City of Portland, Maine - Building or Use Permit Application

Permit No: 02-1025	Issue Date: SEP 12	CBL: 337 C059001
-----------------------	------------------------------	---------------------

Proposed Project Description:
Removal of existing deck - rebuild new 9' X 10' deck in same footprint

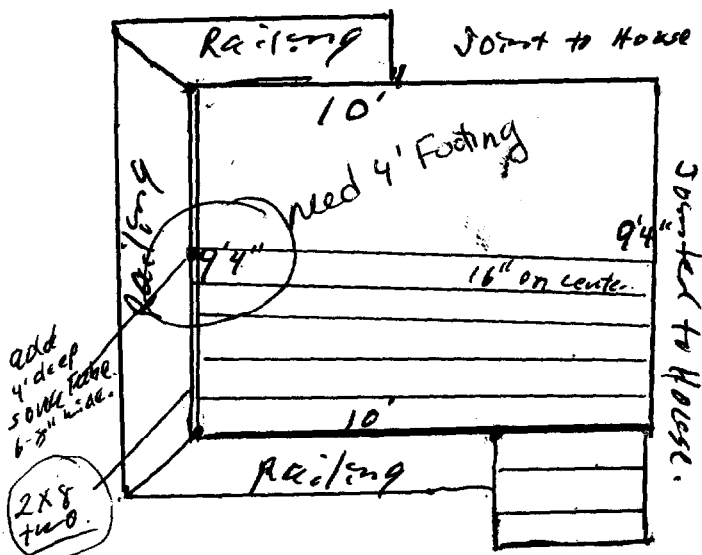
Need to add 4' ceiling of outside rim to decrease span of girder
